**PRELIMINARY REVIEW
NOT FOR CONSTRUCTION**

THE MILLER RESIDENCE
5050 NEEPER VALLEY RD
COMPUTER FILE # P1800-0000

SITE PLAN
VICINITY MAP
SITE NOTES

Sheet #
SP1
OF 1 Sheets

SITE PLAN
SCALE: 1" = 20'

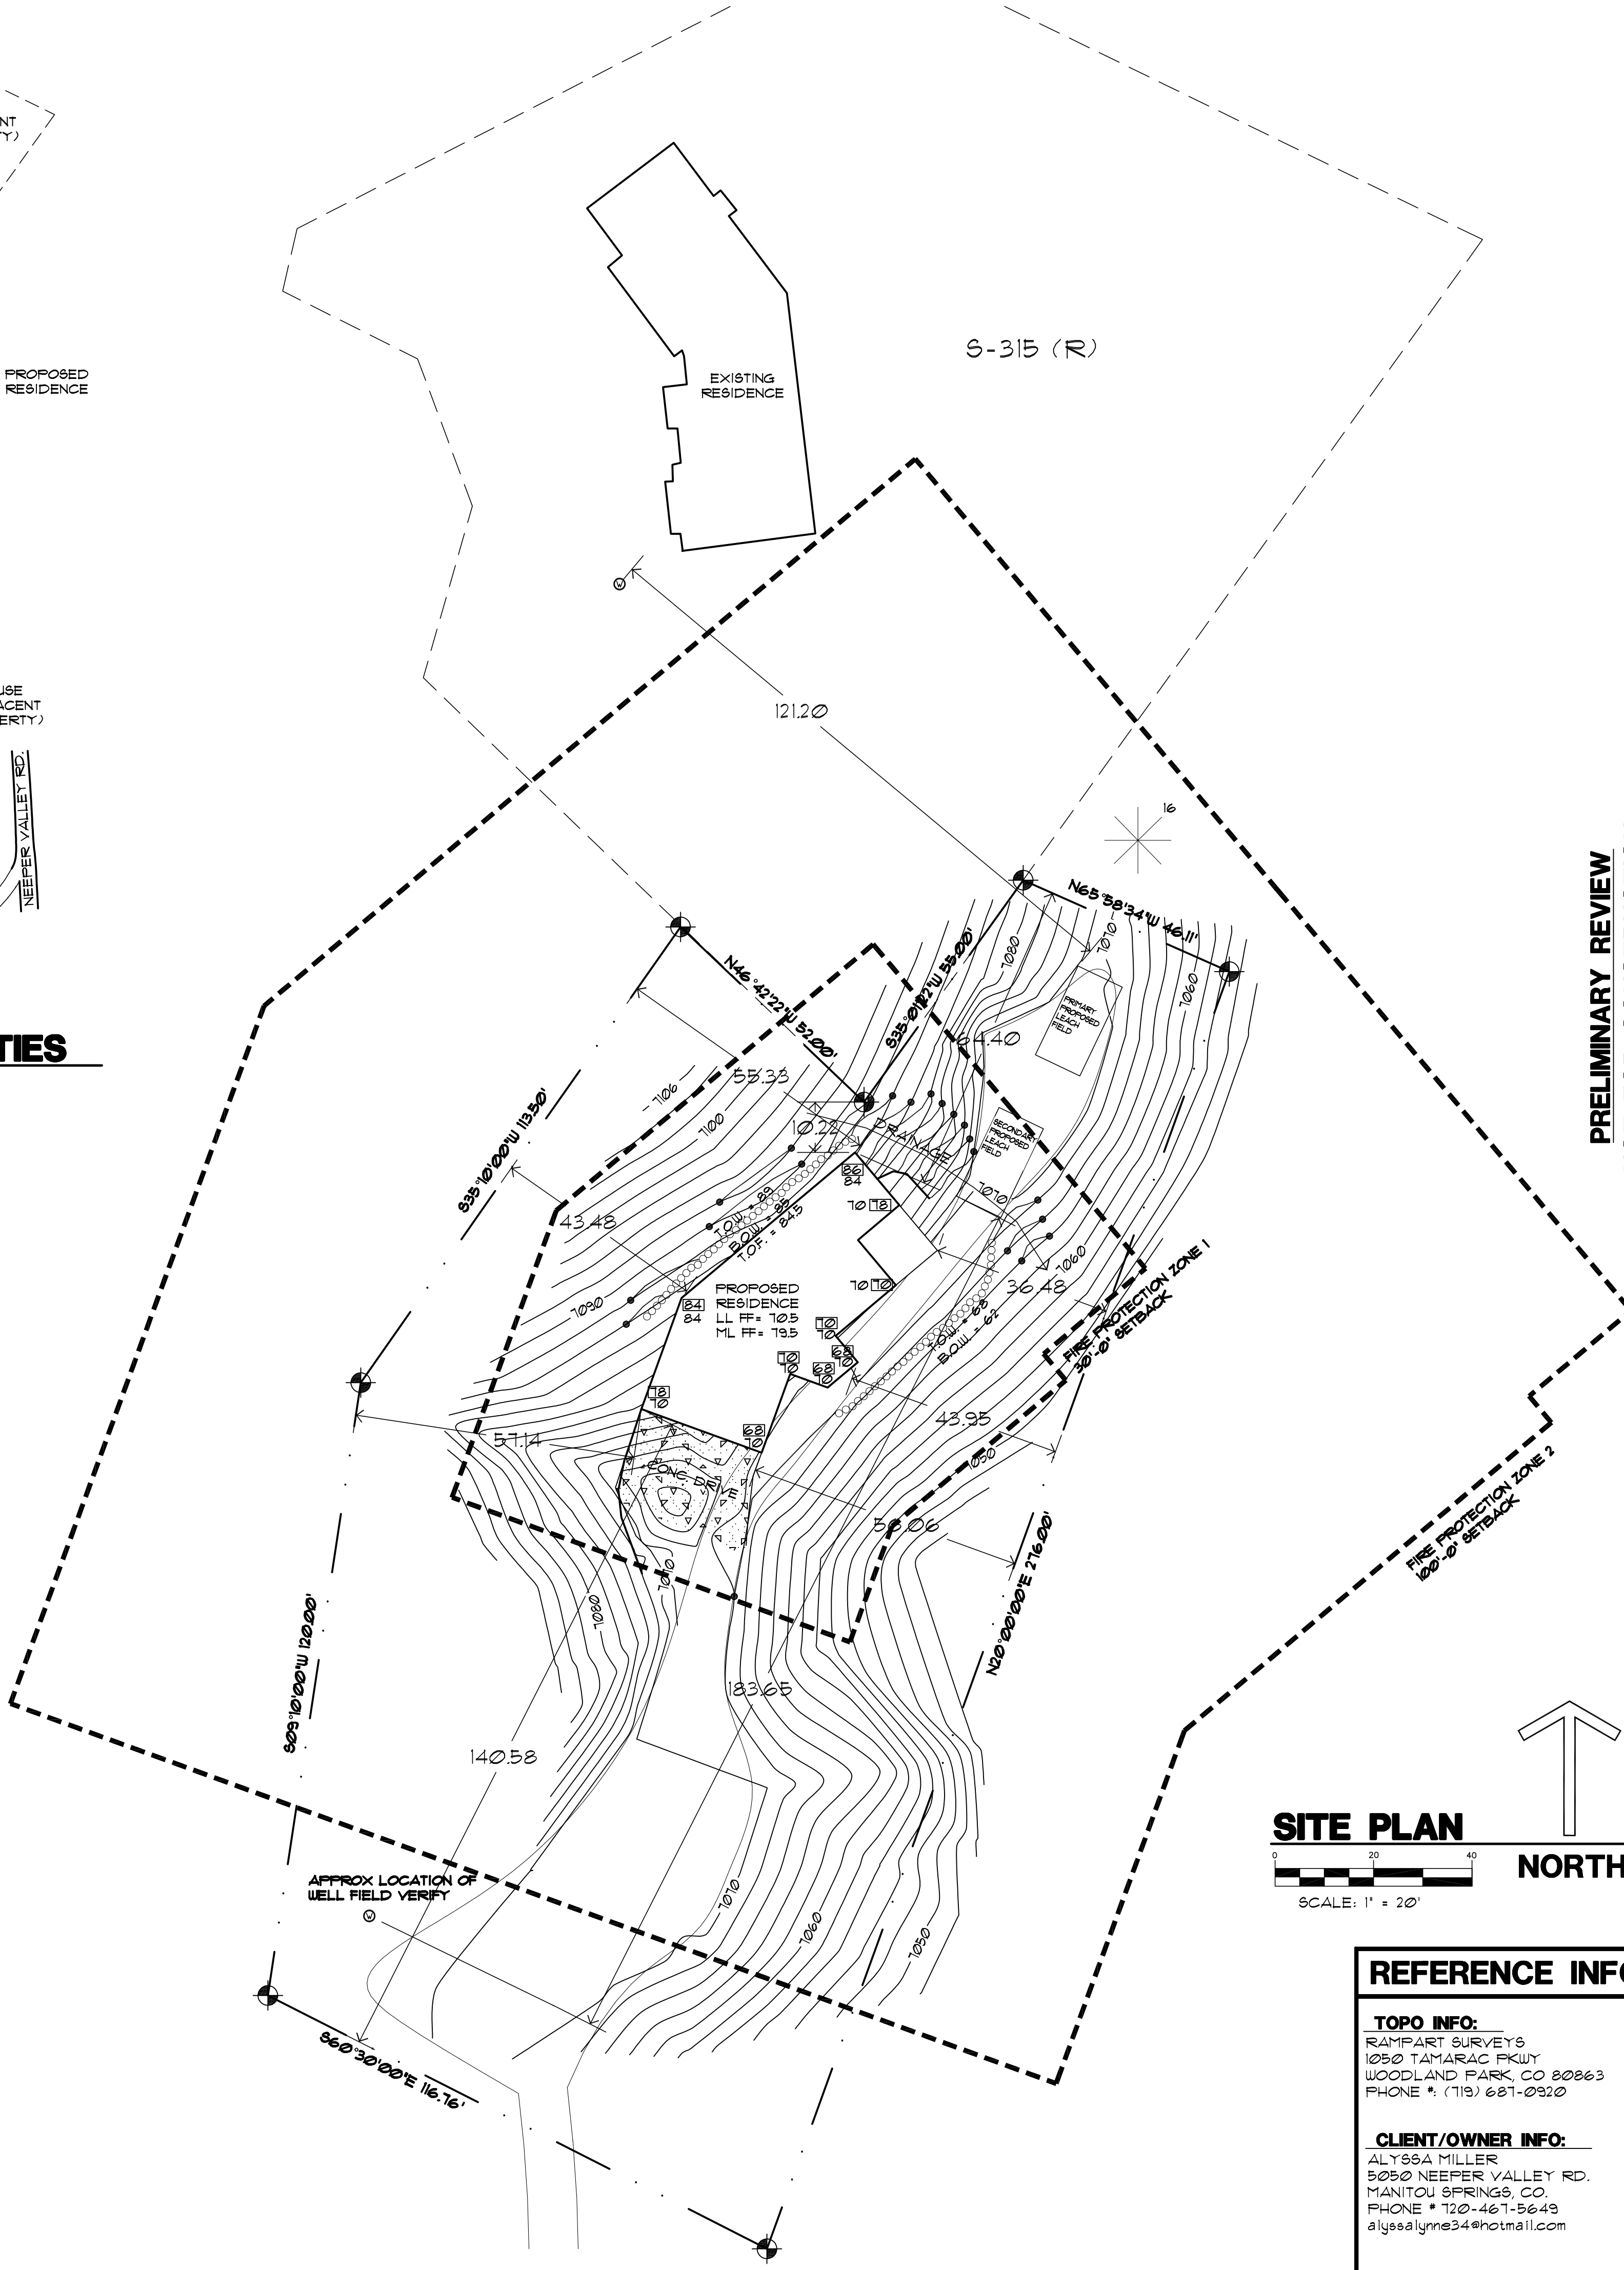
Please add a note to the site plan that says something to the applicant acknowledges the presence of geologic hazards. Staff recommends reaching out to Colorado Geologic Survey for the preferred language for this note.
